PLAN REVIEW SHEET

Petition #: RZP 2021-033

Address: 1335 South Clarkson Street, Charlotte Pipe and Foundry

Request: UMUD-O

RZ-1.0

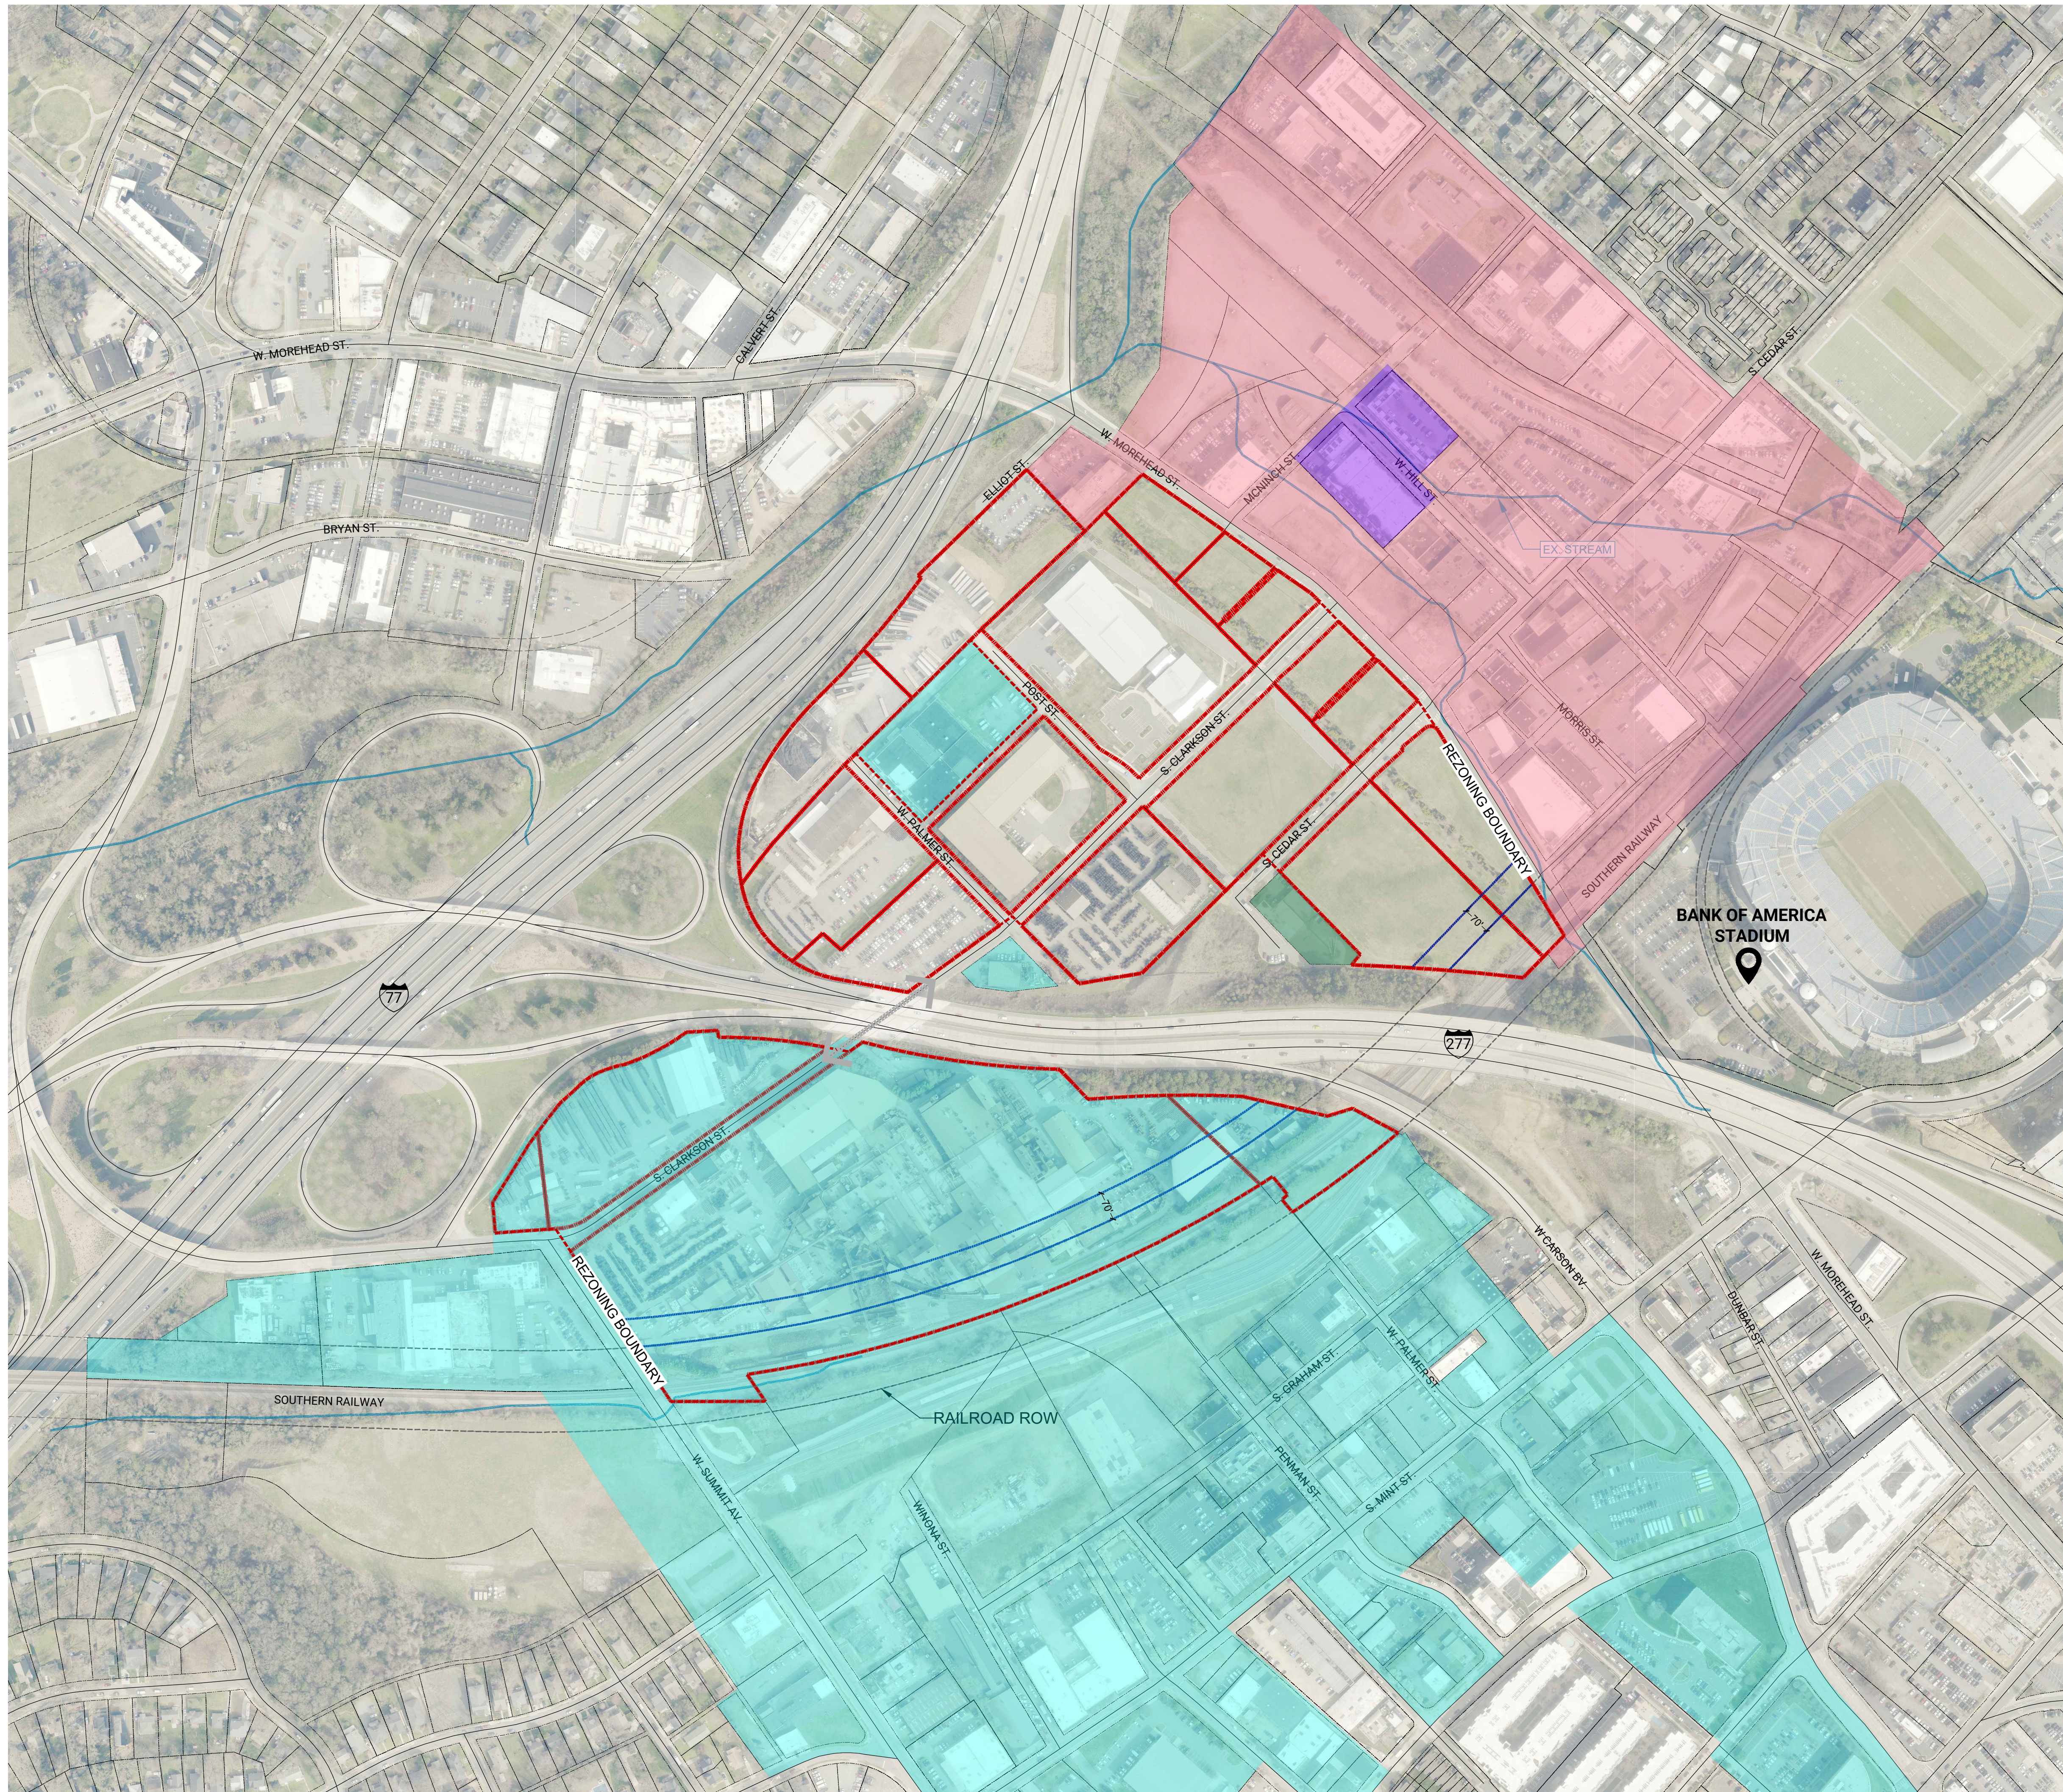
1. Right-of-Way Reservation Area Provisions. The Petitioner shall reserve, for the sole benefit of the City of Charlotte (and, as applicable, of any successor entity that assumes some or all of the City's responsibilities for providing light-rail service, such as a regional transit authority, with the City and all such successor entities collectively referred to as "CATS"), the area (the "Reservation Area") that is identified on the Rezoning Plan as the "Light Rail Conceptual Right-of-Way Reservation," which follows parallel to the heavy rail alignment but, subject to written approval of CATS, may slightly deviate from this area. The Reservation Area shall not extend more than one hundred (100) feet from the heavy rail right-of-way, as generally depicted on the Rezoning Plan.

- b. The Reservation Area shall be seventy (70) feet in width and cannot be any wider. If CATS should determine, in its sole discretion, that the full seventy (70) feet is unnecessary for CATS's purposes, CATS shall, in writing to the Petitioner, release from the requirements of this Section V.f that portion of the Reservation Area that CATS determines is unnecessary.

- c. Only the following construction, installation, and development activities are allowed within the Reservation Area, and no others: grading and the installation and maintenance of pavement, driveways, sidewalks, surface parking areas for bicycle, scooter or similar vehicles but excluding automobiles and trucks, landscaping, and comparable non-vertical improvements. For clarification only, none of the following may be placed, developed, constructed, installed, or

maintained anywhere within the Reservation Area: (1) buildings or other vertical structures, (2) utility lines or facilities, (3) detention facilities, or (4) Wi-Fi, telecommunication or similar antennas or transmission devices for use by third parties to provide services to customers.
